RE: **GAHP Silver Downtown**
800 Silver SW
Grading Plan Engineer's Stamp Date: 2/21/2017
Hydrology File: K13D013

RE: **GAHP Silver Downtown**
800 Silver SW
Grading Plan Engineer's Stamp Date: 1/30/2017
Hydrology File: K13D013

Based upon the information provided in your submittal received 2/10/17, the Grading Plan is not approved for Building Permit. The following comments need to be addressed for approval of the above referenced project:

A4 OVERALL GRADING PLAN
1" = 20'-0"

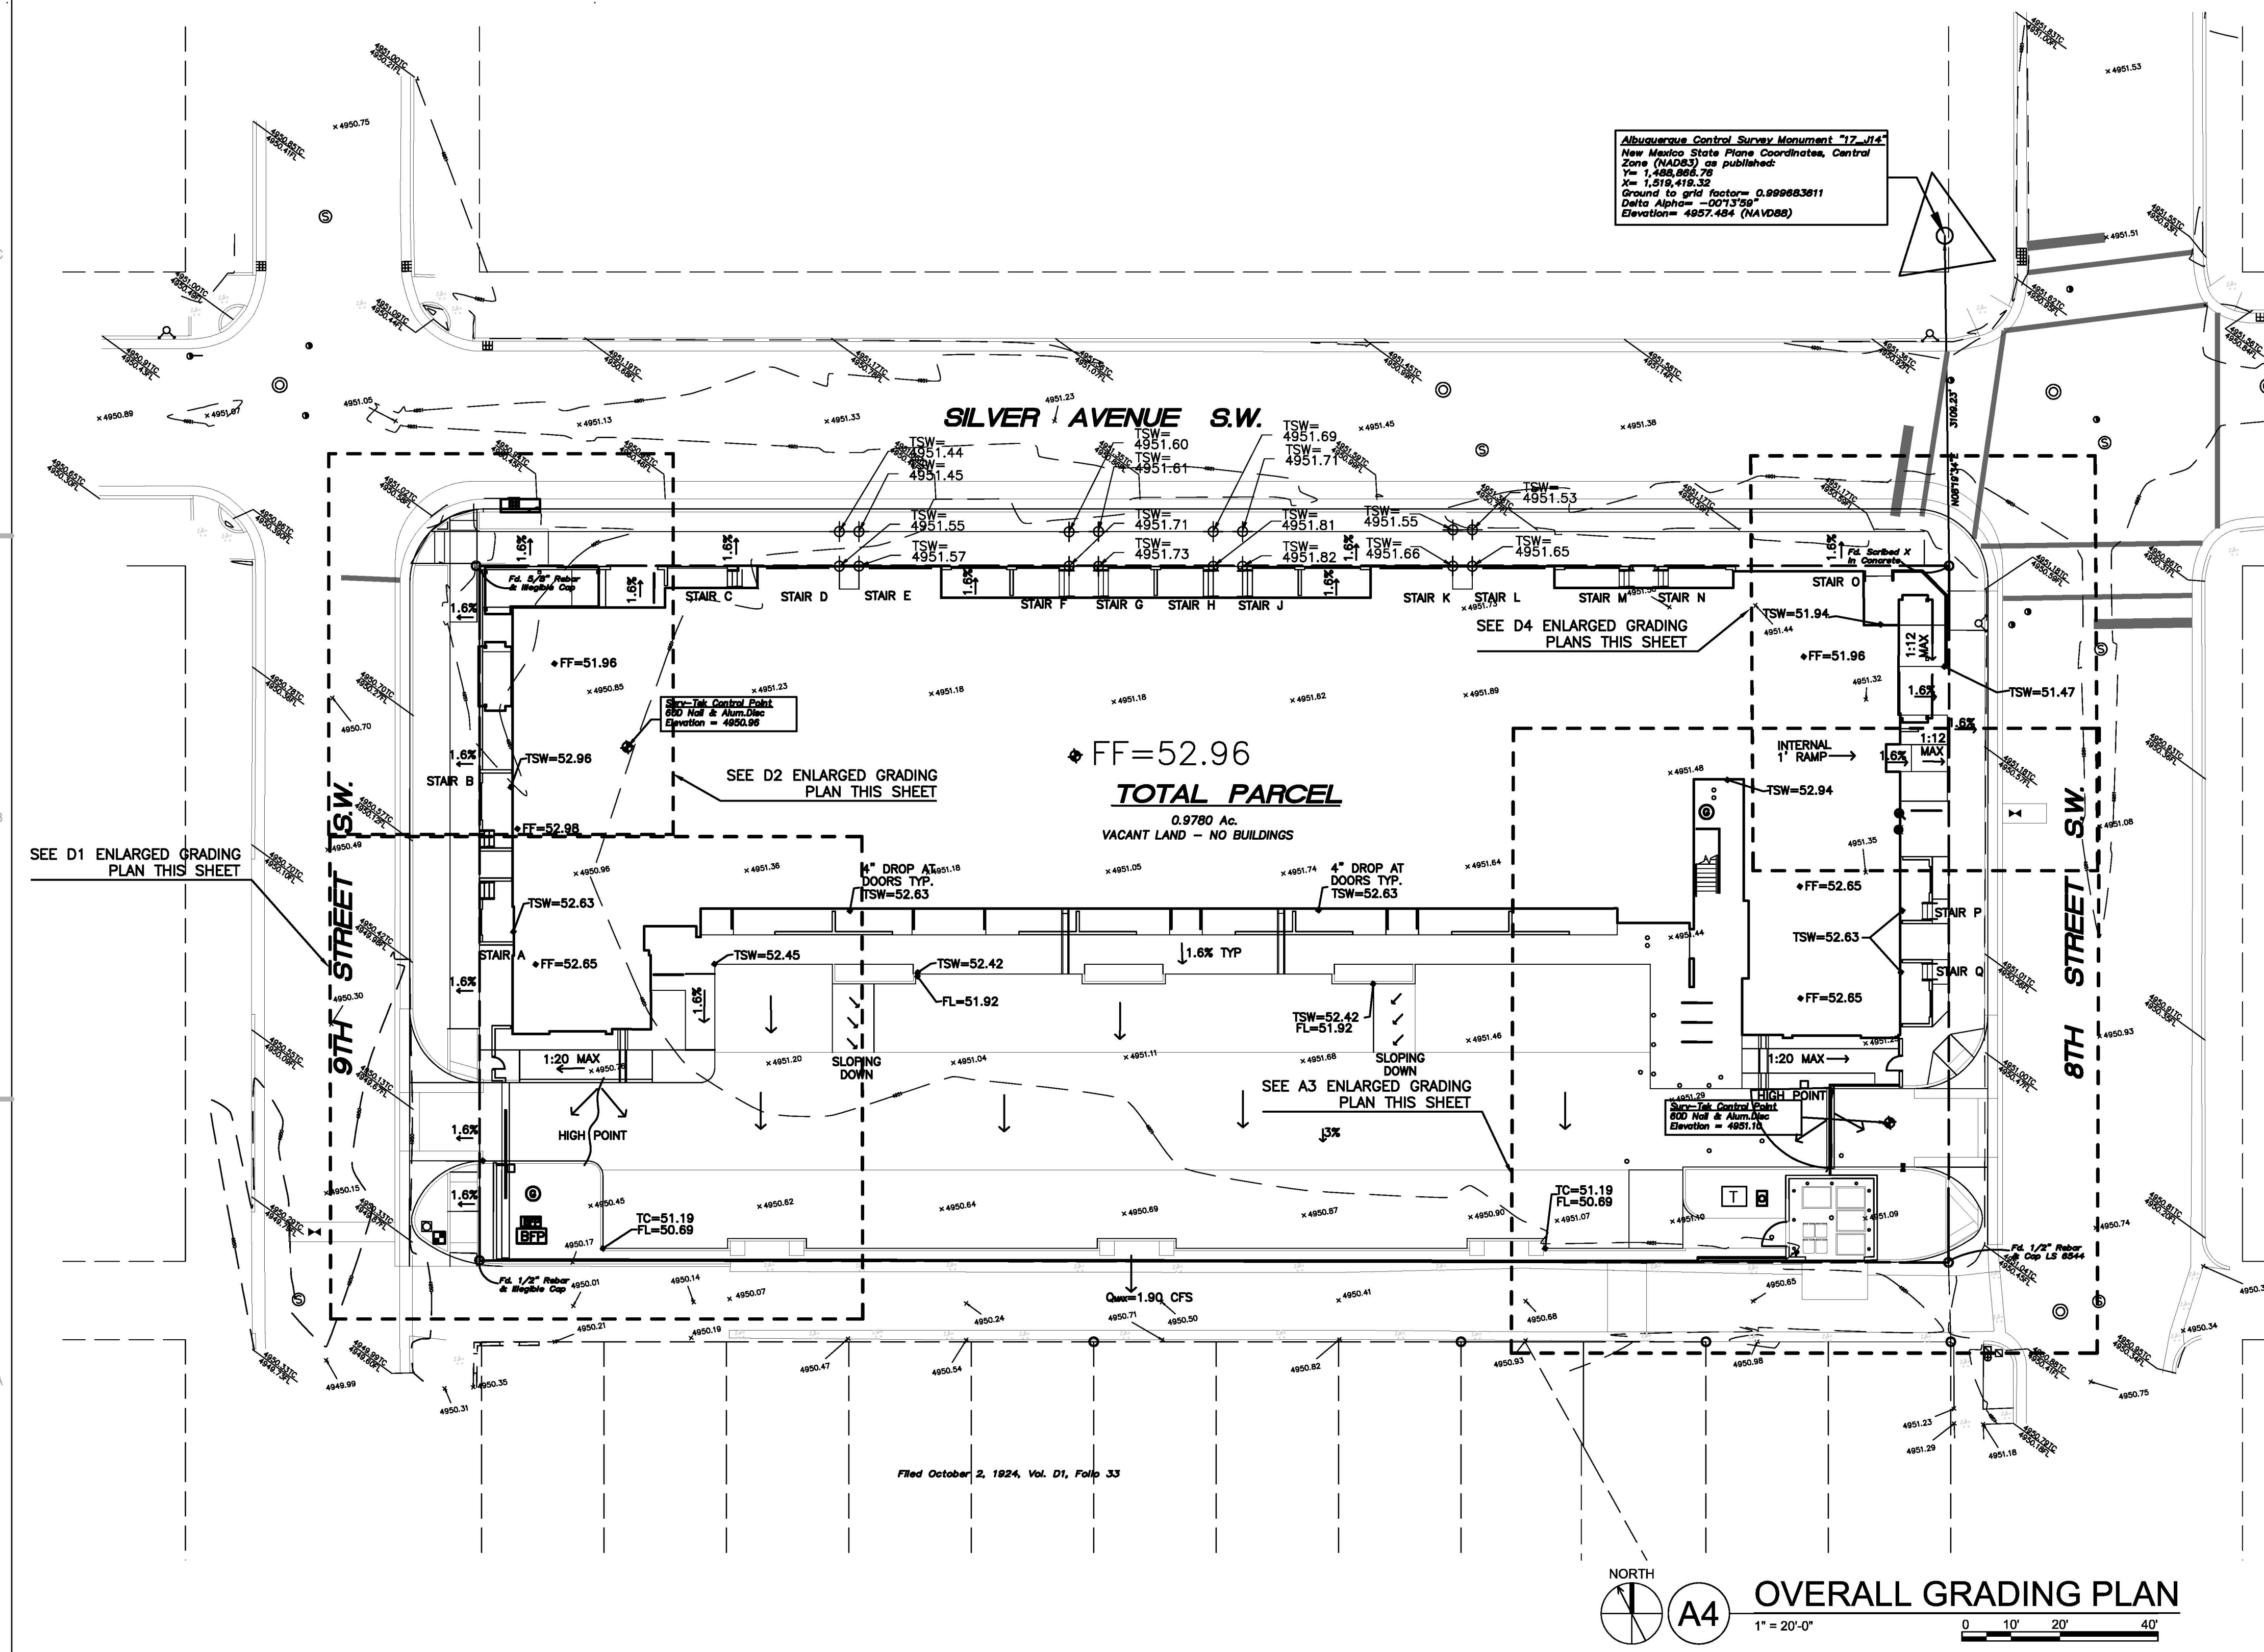
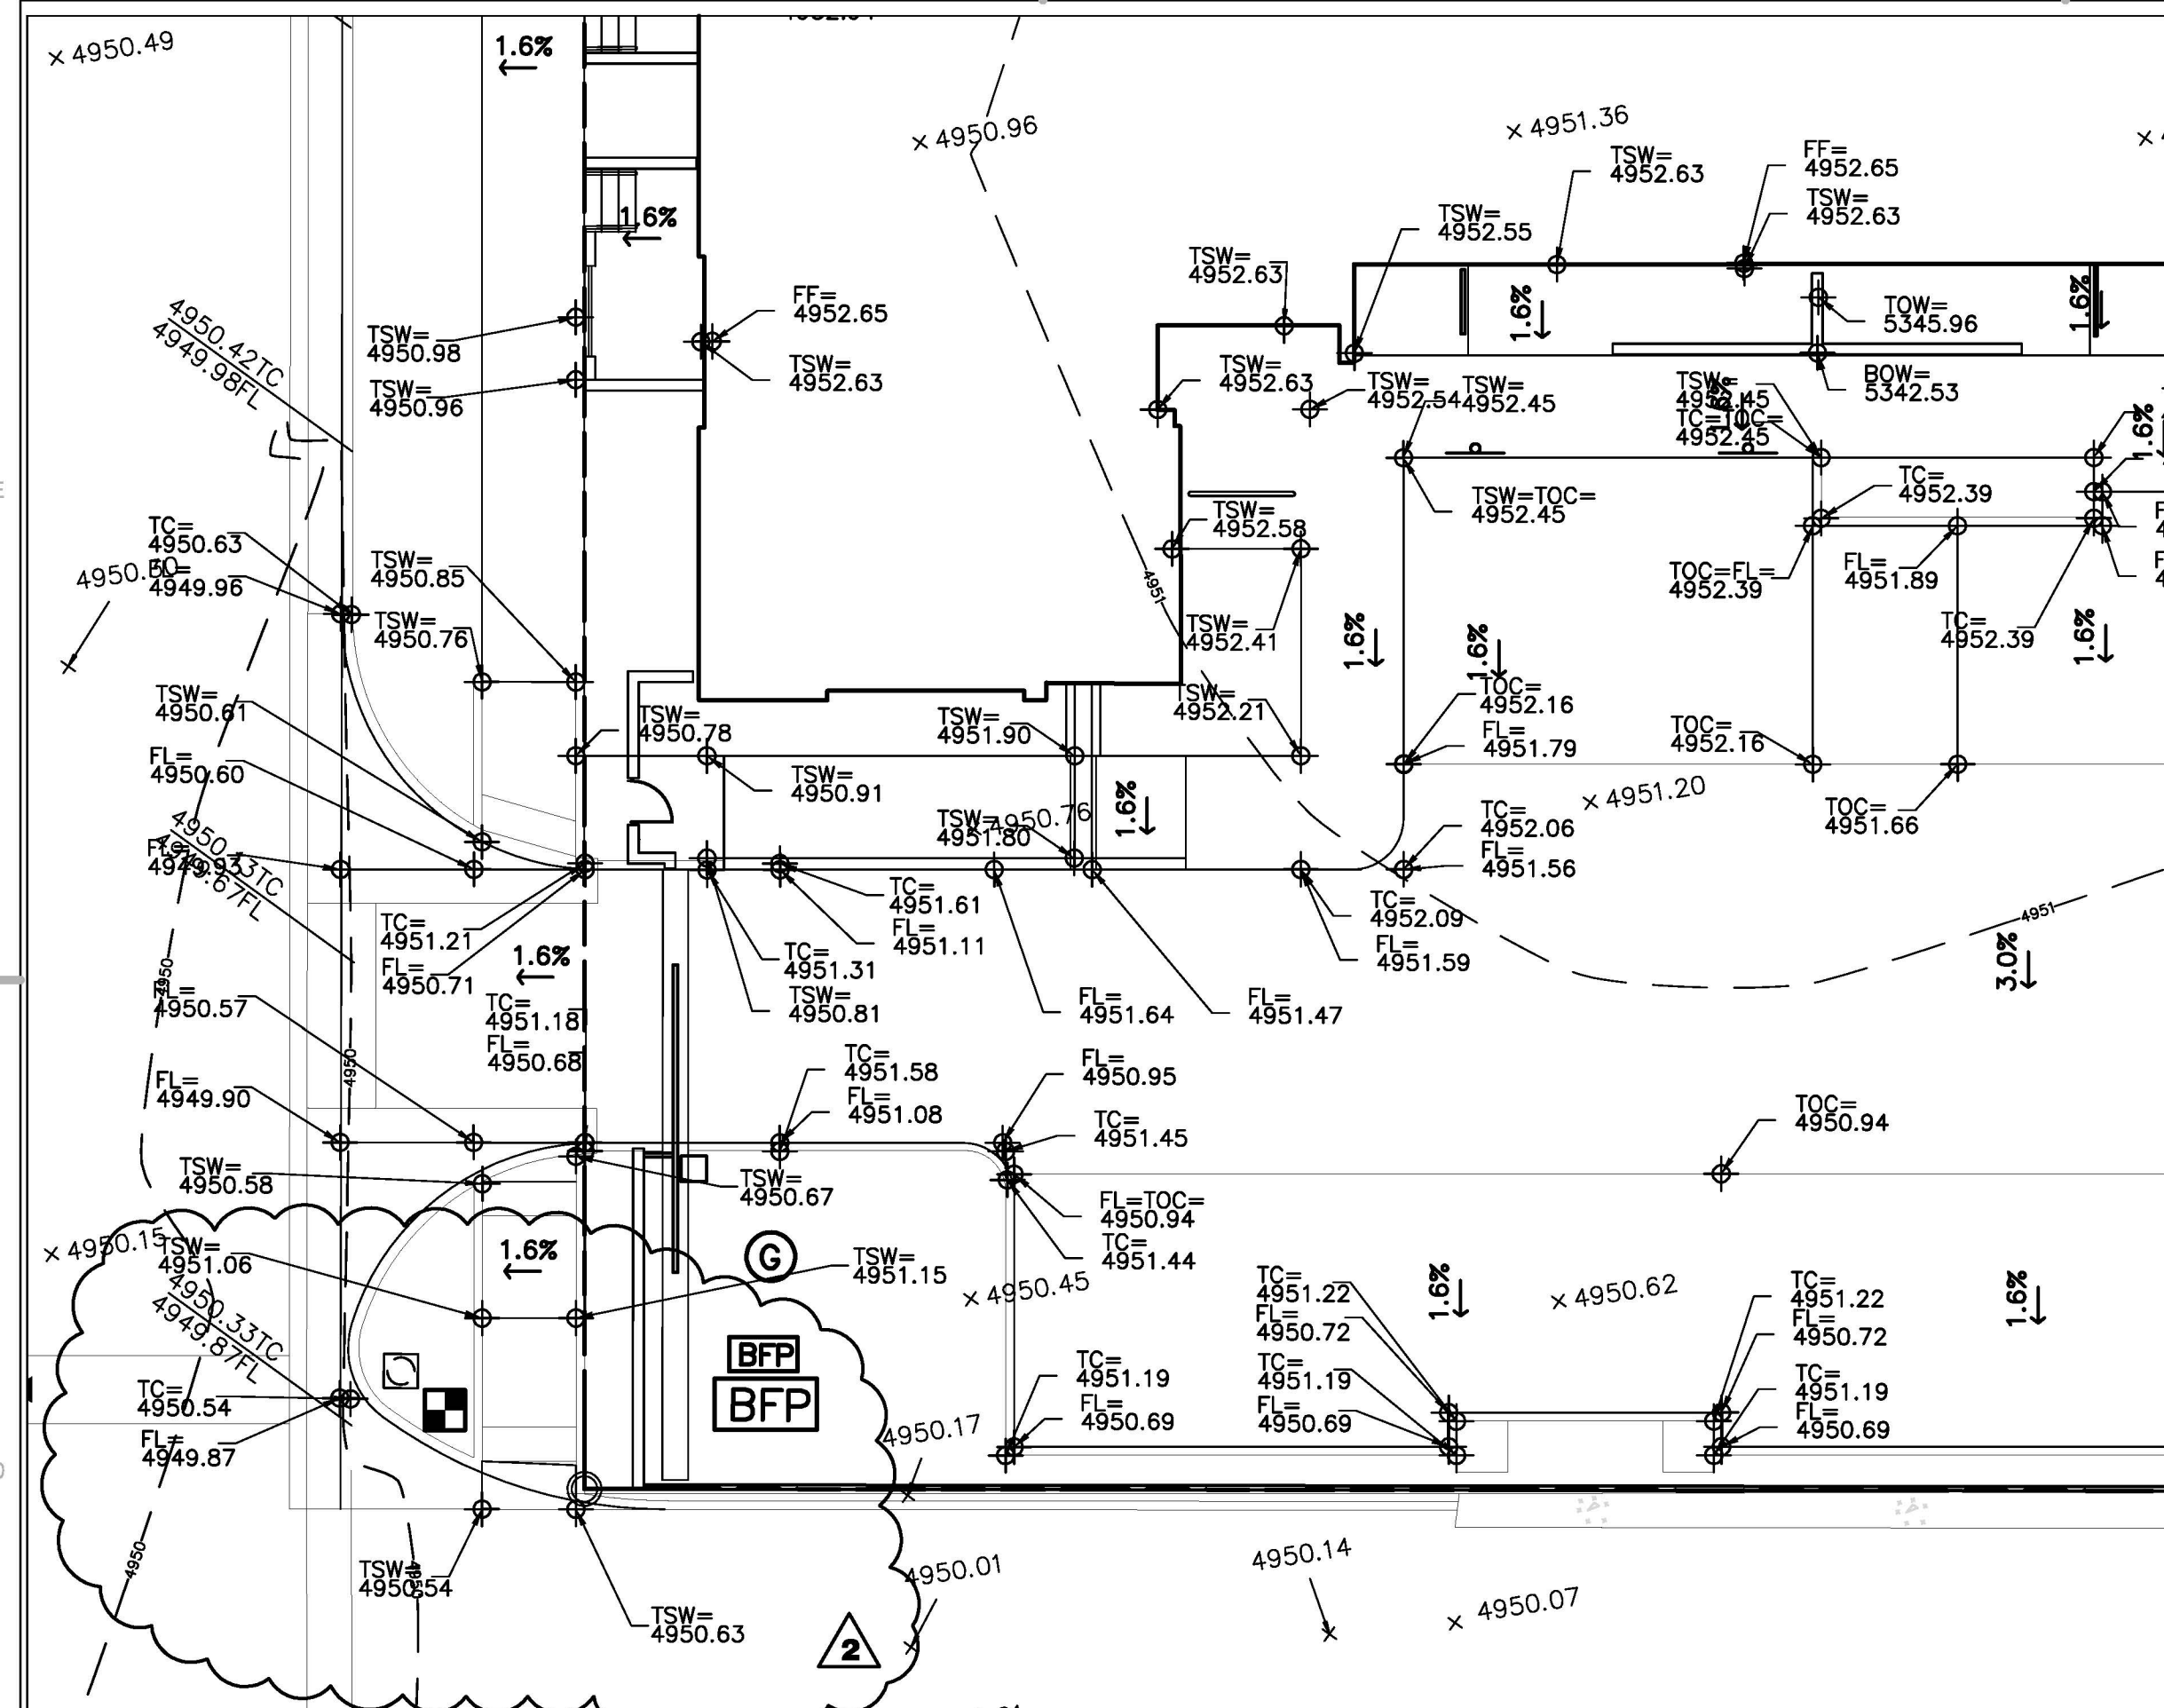
3. There is a reference to a constrictor plate for the draining the parking lot to the ally, but none is shown on the construction plans. Provide location and details for this.
Constrictor plate no longer used. Setting curb height to limit ponding.

4. It was agreed during the review for SPBP that the wide buffer between the back of curb and the edge of sidewalk would be used to help mitigate nuisance ponding on Silver and 9th Street, by including new curb cuts on the ex. curb. This would help the site achieve the capture of the first flush volume. It needs to be shown on the plan.
No longer possible due to fire marshal requests.

5. The 2" depression in the sidewalk buffer does not account for the running slope along top of curb and along the sidewalk. This means the depression will not retain a uniform 2" deep pool. This area needs to be supplemented with a 5:1 gravel filled swale and curb cuts with shallow ponding to allow in flows from Silver and 9th Street.
9th Street and Silver to have 5:1 swales.

6. The ponding volume for the parking area does not account for the running slope across the parking lot toward the ally. This means the gravel areas will not retain a uniformly deep 2" of water.
and curb opening on 9th Street.
Volumes adjusted. 5:1 slopes added.

This was adjusted to account for slope. 2" to centroid of volume retained
